Subject: RE: Planning Consultation on Y/23/20/DOC

Engineers Comments Regarding Surface Water Drainage

APPLICATION NO: Y/23/20/DOC

Description of Works: Approval of details reserved by condition imposed under ref Y/70/19/HH relating to Condition No 3 - surface water drainage scheme

DRAINAGE LEGEND (1:100)

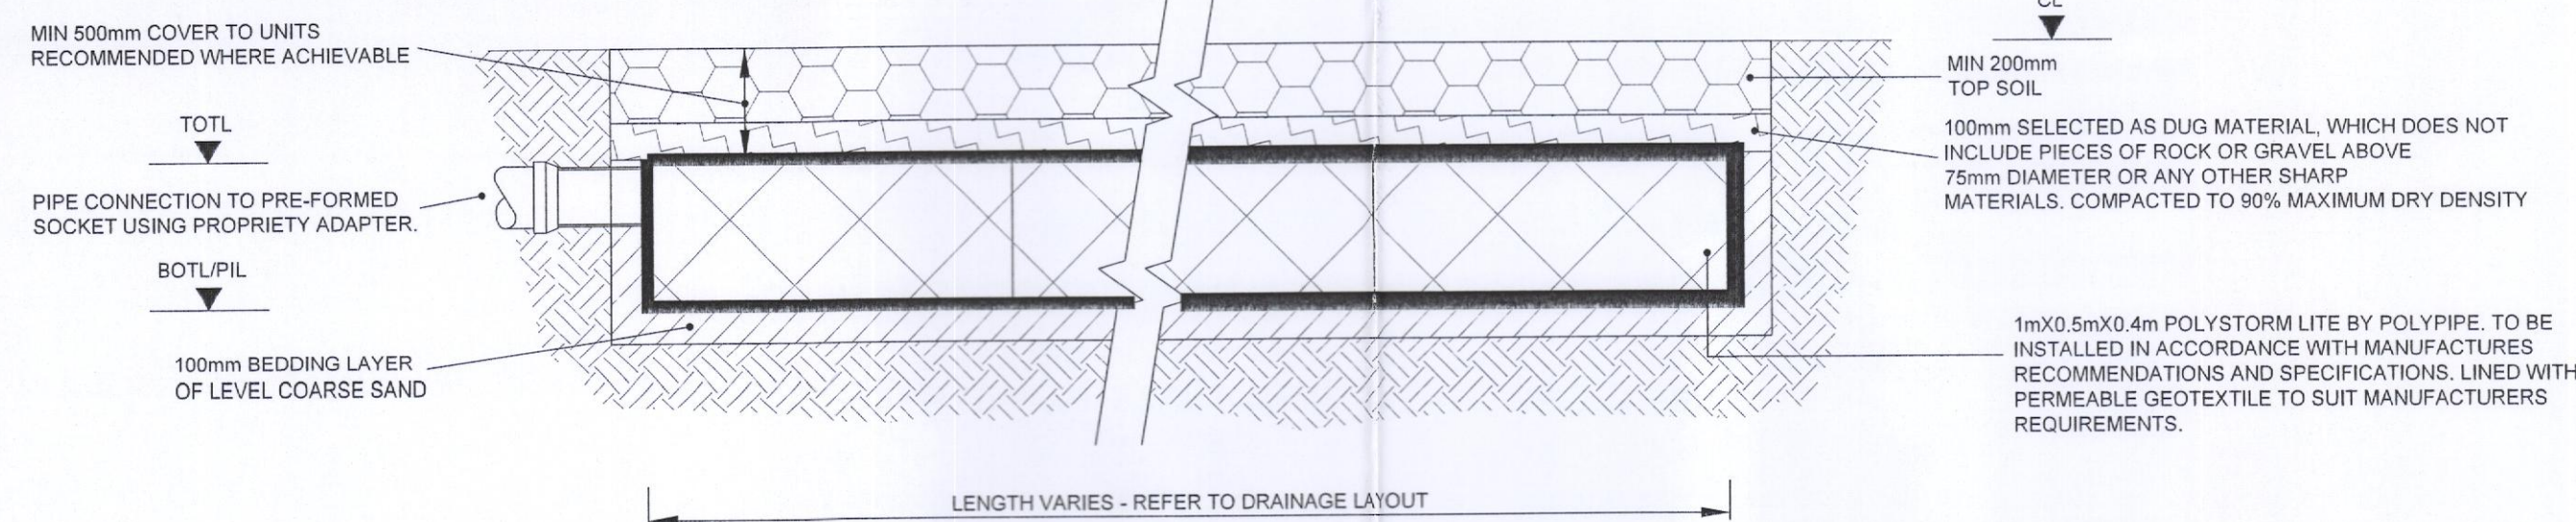
The plans lack a note to state the pipe materials (when not adopted), however, it is trusted that this can be added by the applicant before issue to a contractor.
